Priory Farmhouse, Freefolk Priors, Freefolk

Appendix 1 - Heritage Impact Drawings

Appendix 2 - Commentary on Pre-Application Advice

PROPOSED PLANS + SECTIONS - INTERNAL CHANGES 1:100@A3

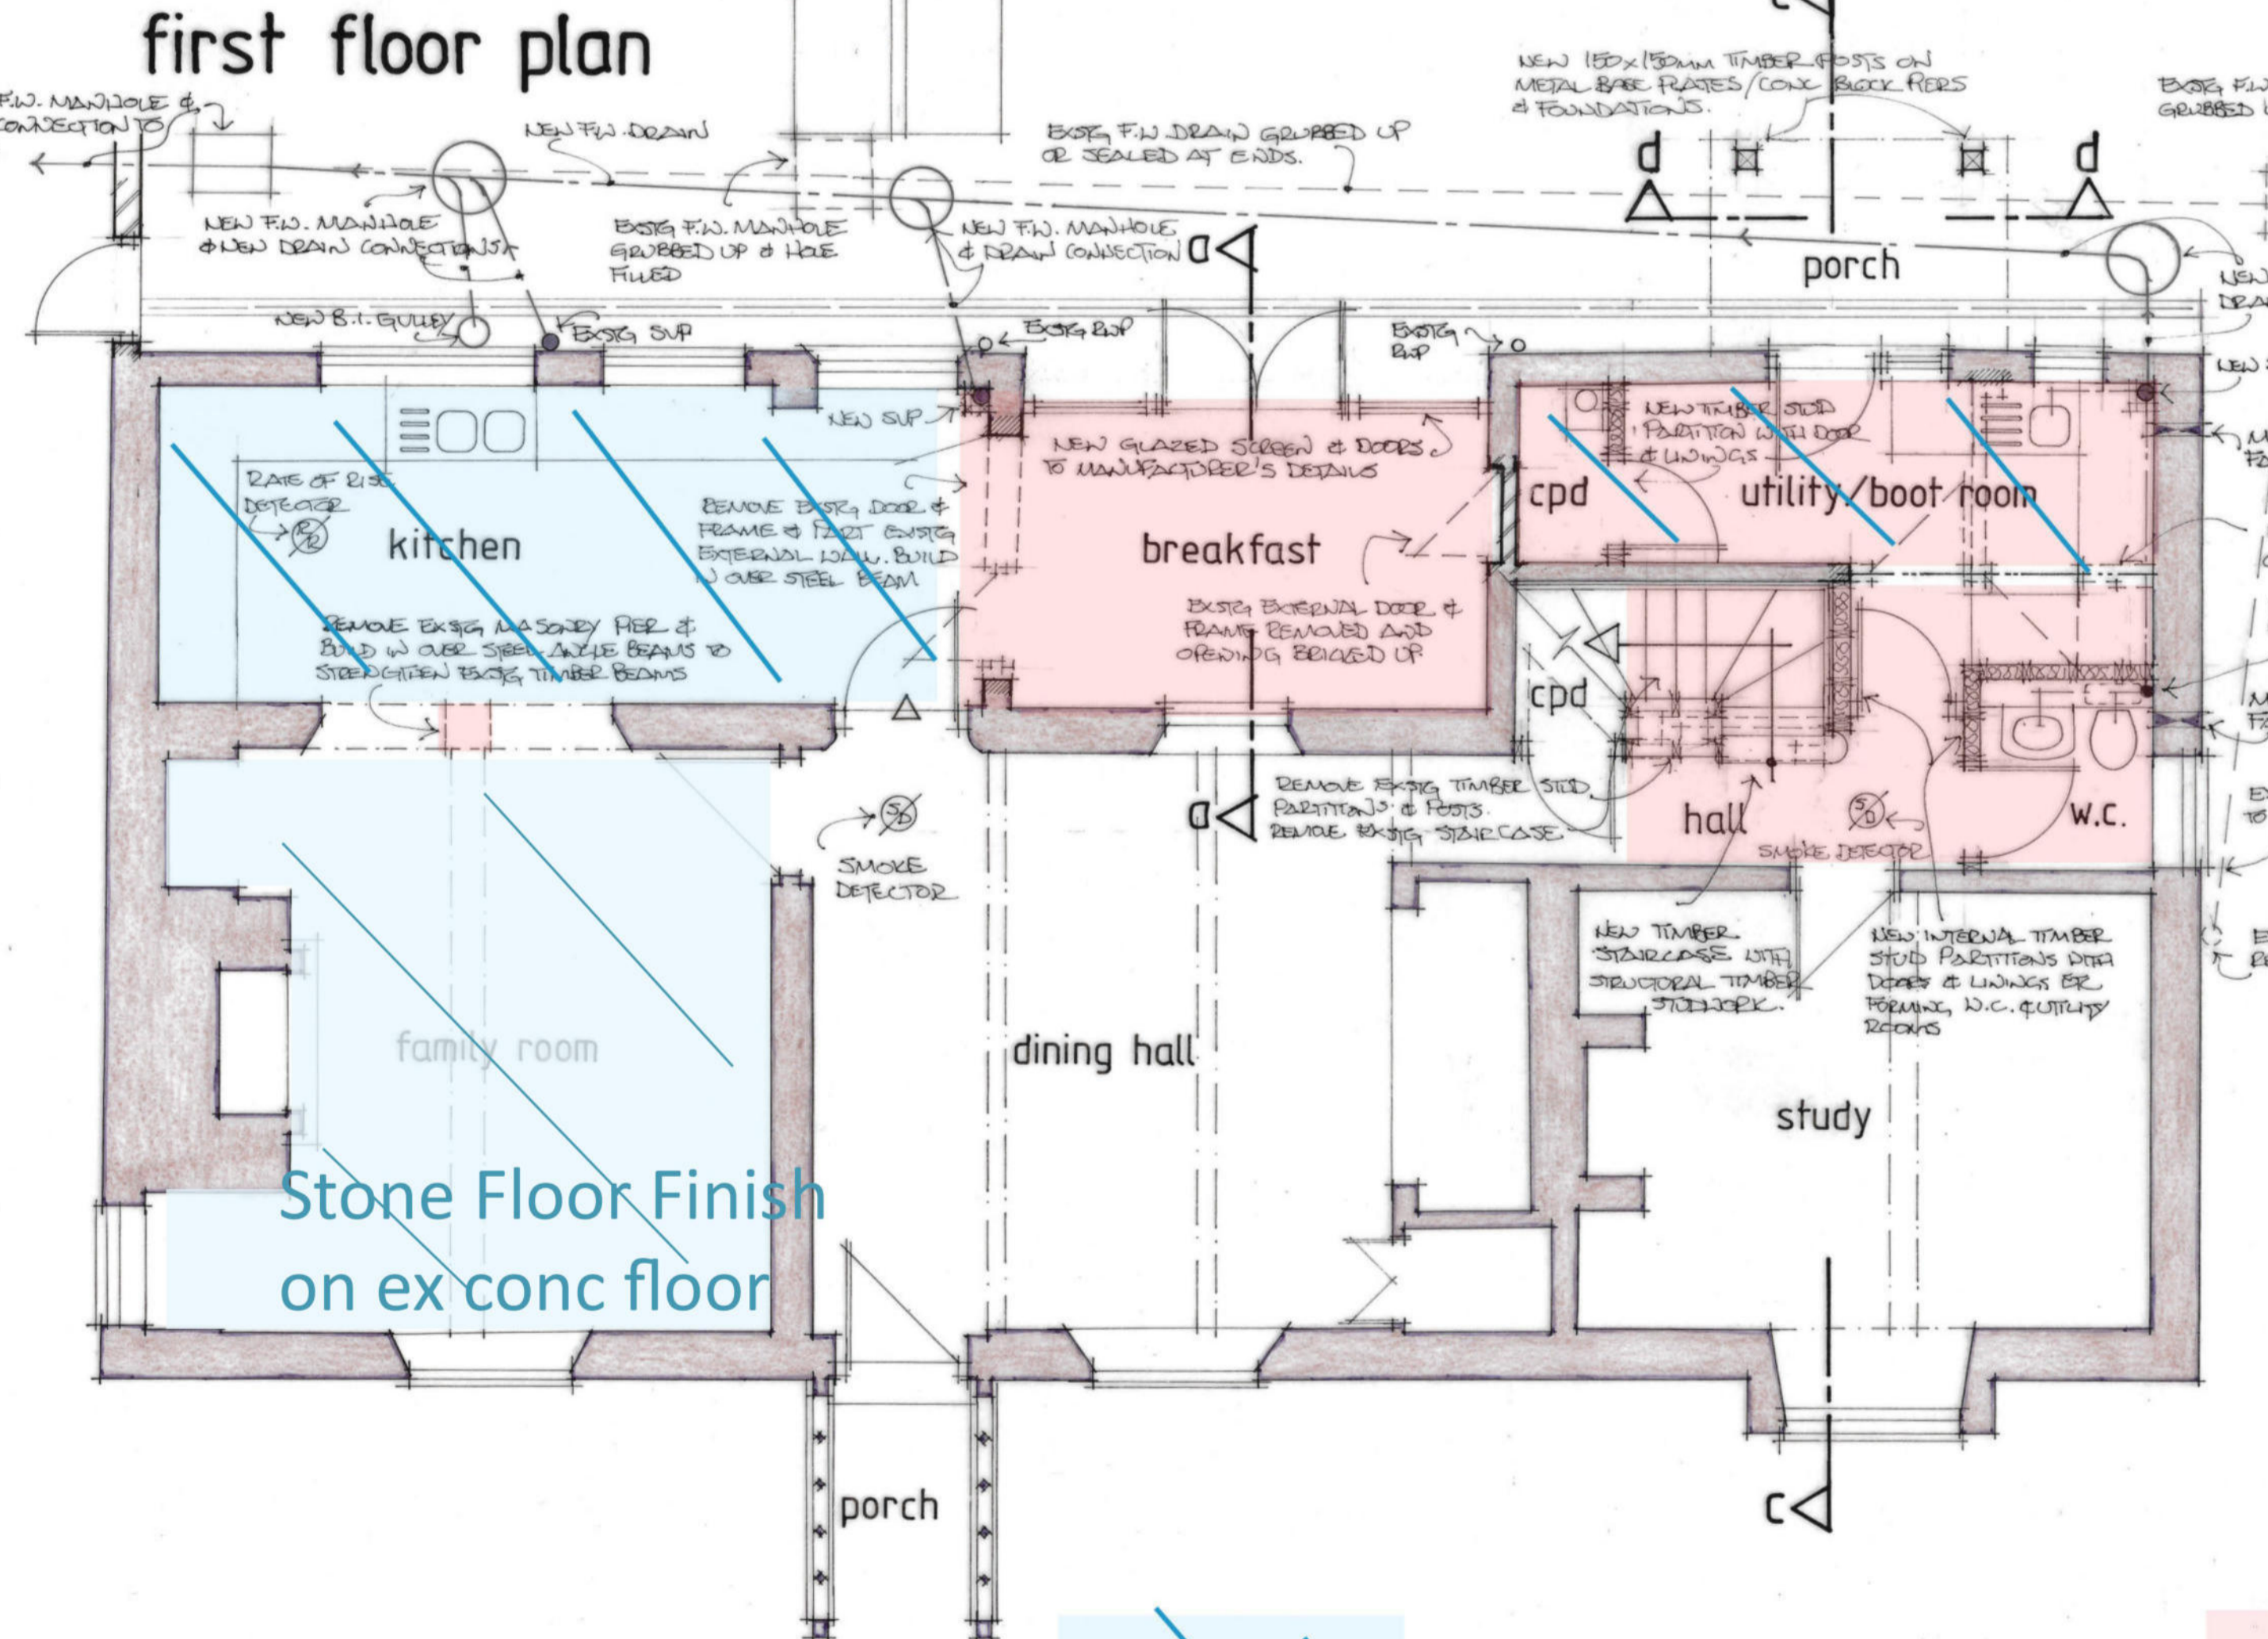
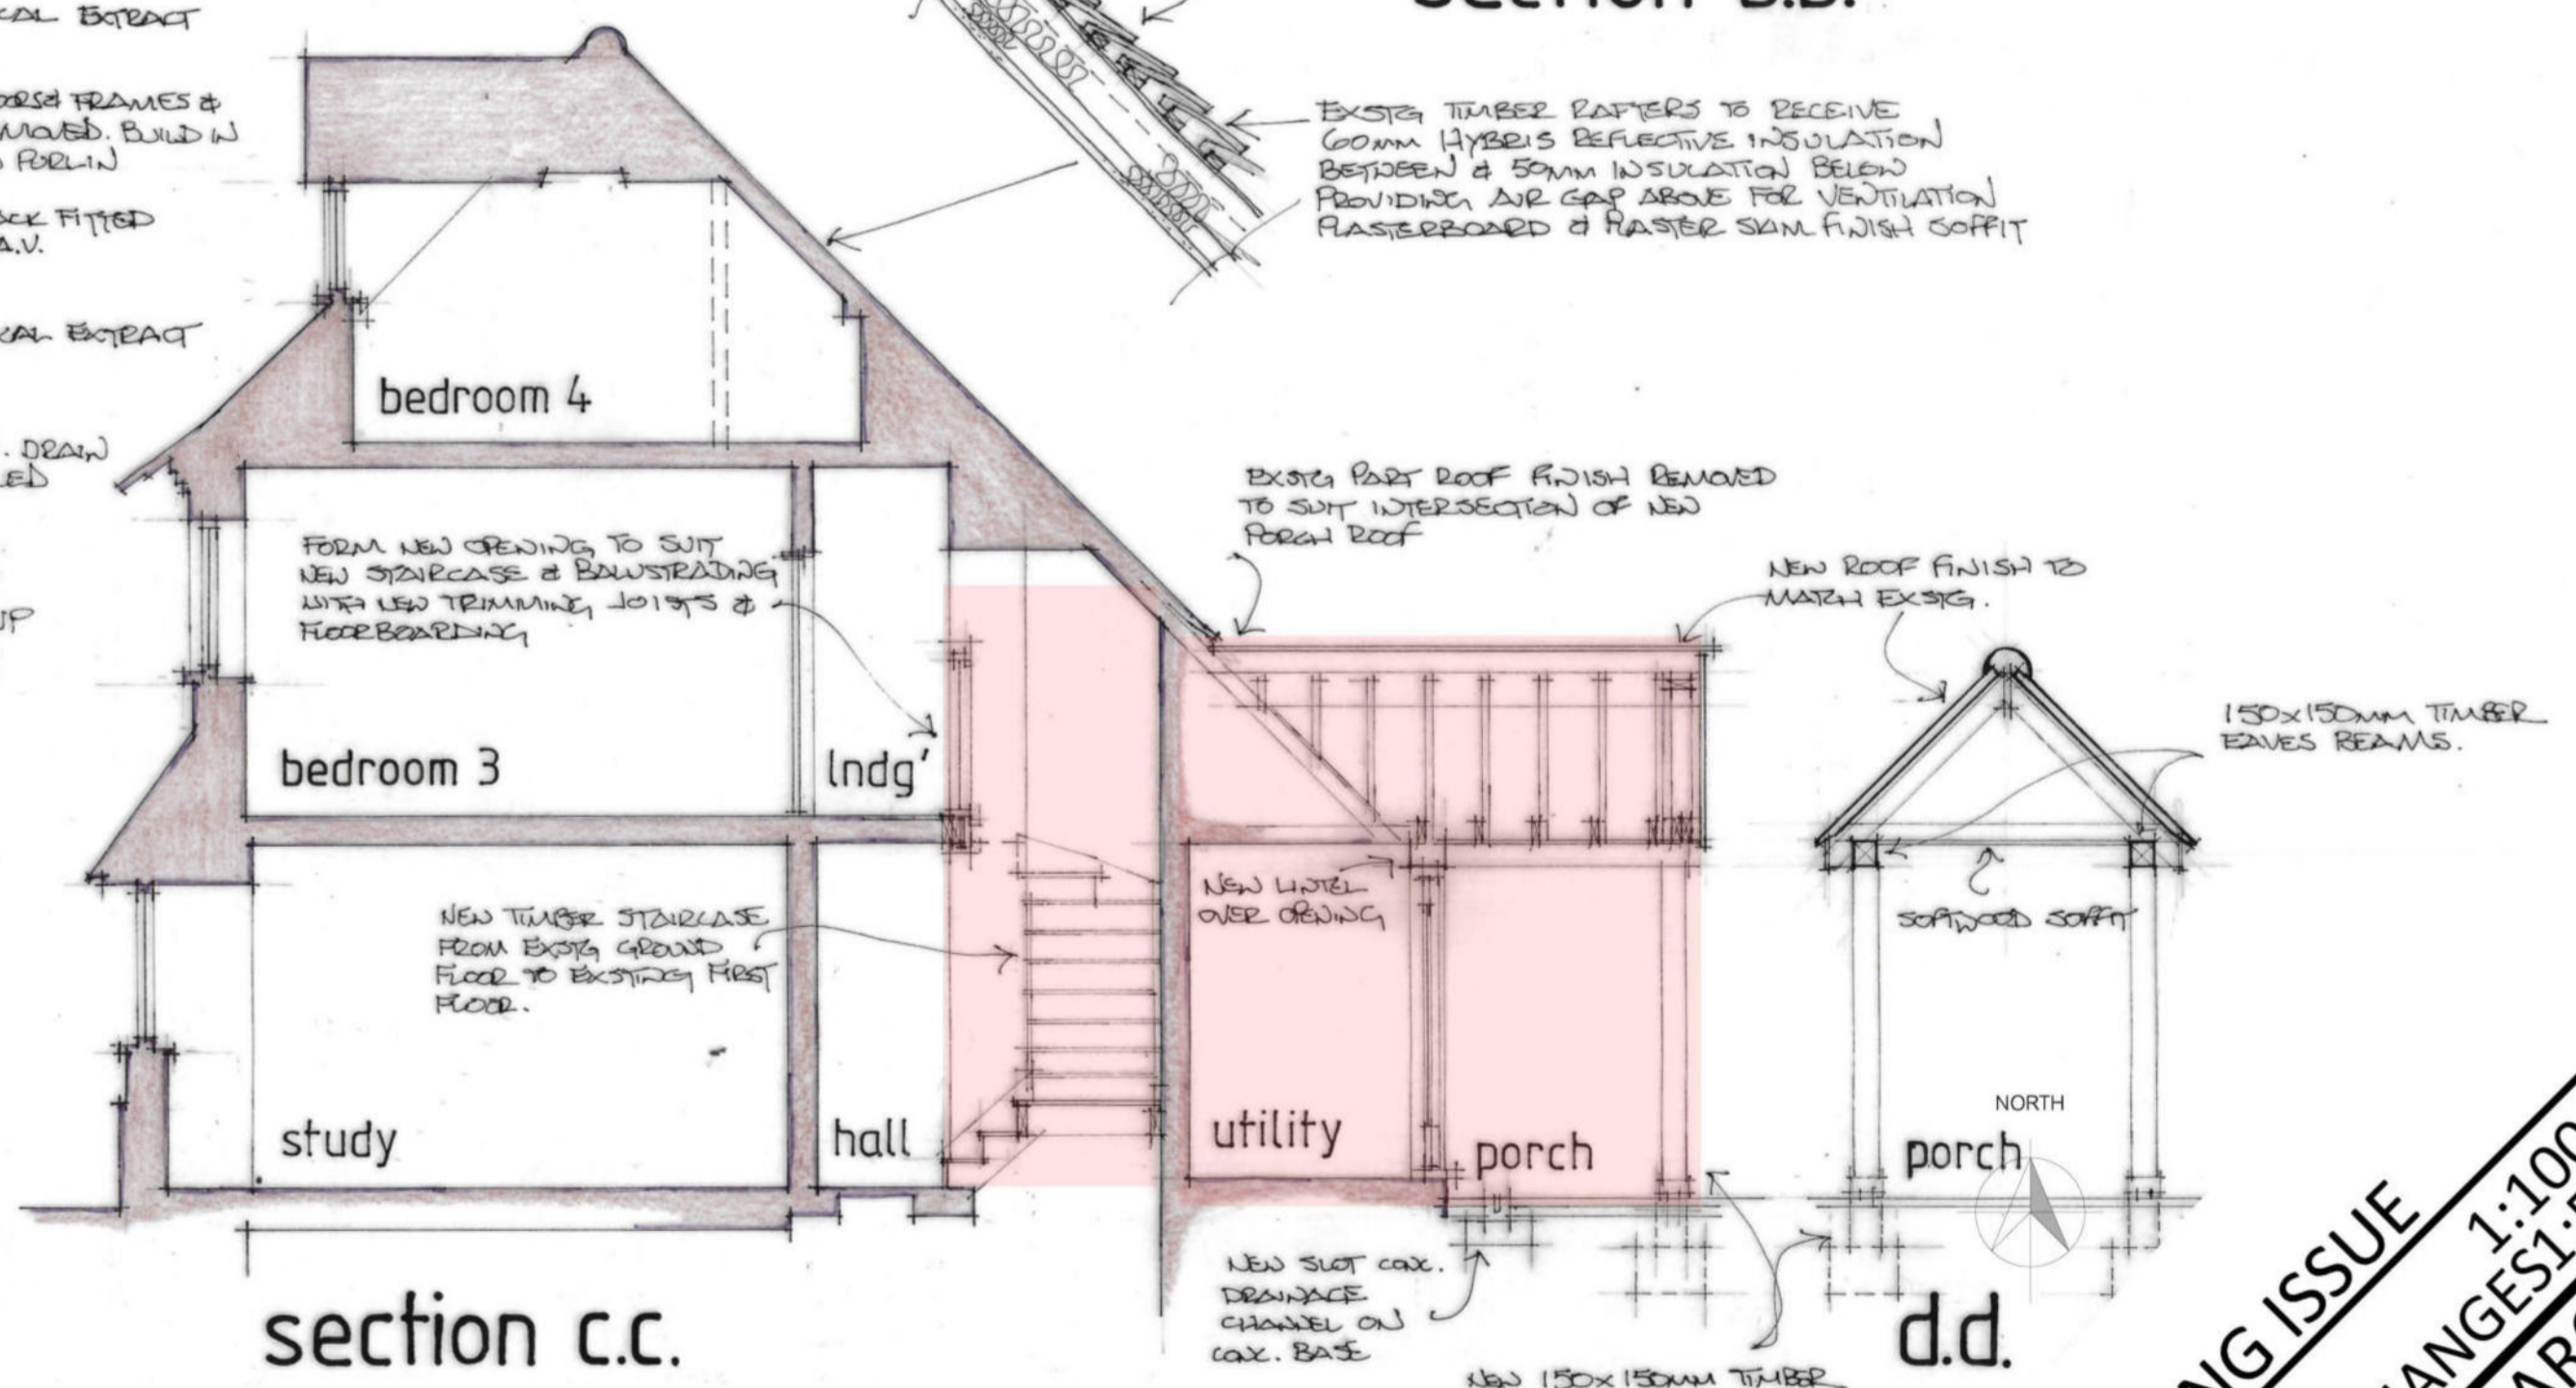
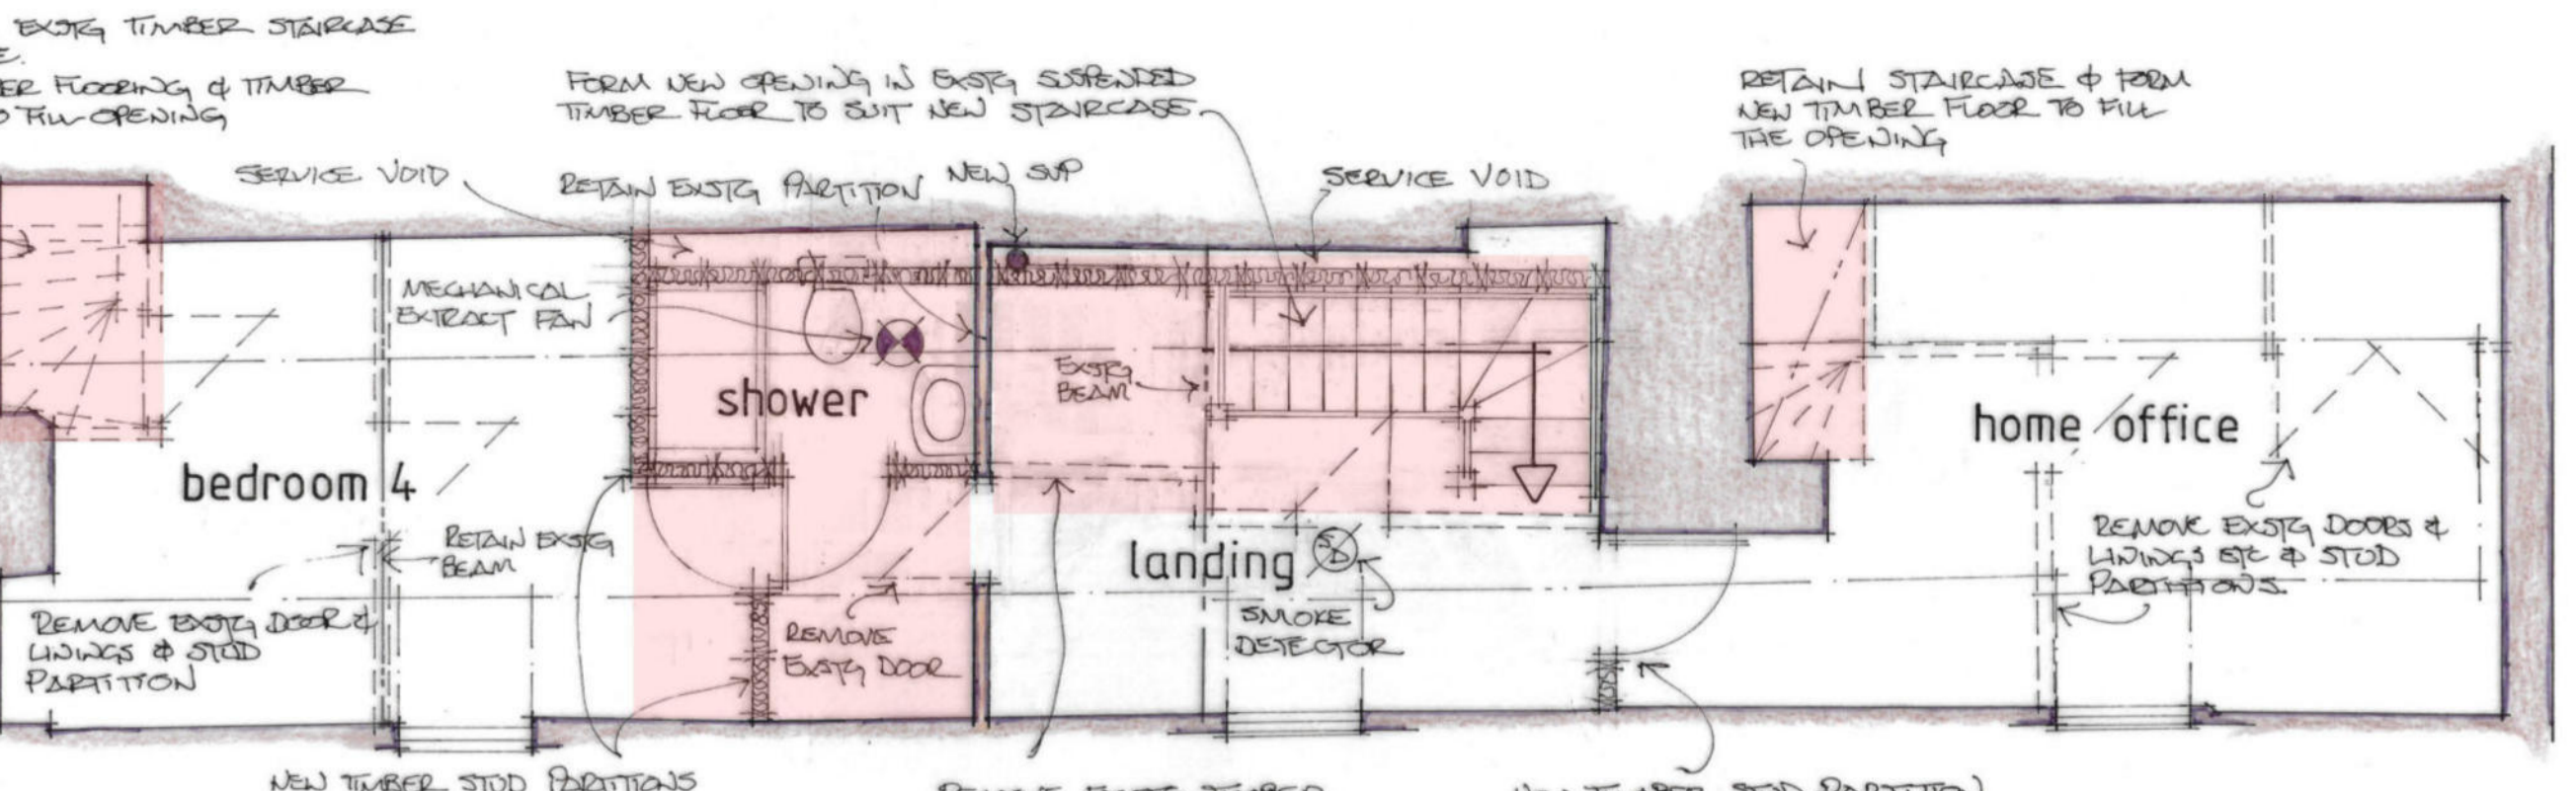
On the basis of your email, I think I could support the installation of the new stair flight the 2nd floor.

Installing a new stair could be justified if the amount of historic fabric to be altered is minimised (principally historic floor/ceiling structure). Unclear what historic fabric remains in Bedroom 2/attic bathroom.

Installing a new stair could be justified if the amount of historic fabric to be altered is minimised (principally historic floor/ceiling structure). Unclear what historic fabric remains in Bedroom 2/attic bathroom.

Note: As drawn the stair location is 'flipped' to avoid the primary tie beam - loss of ex floor fabric being unchanged

The proposed stair with winders at the bottom running alongside the existing 2nd floor beam would minimise the loss of historic structure whilst providing the safer access sought.
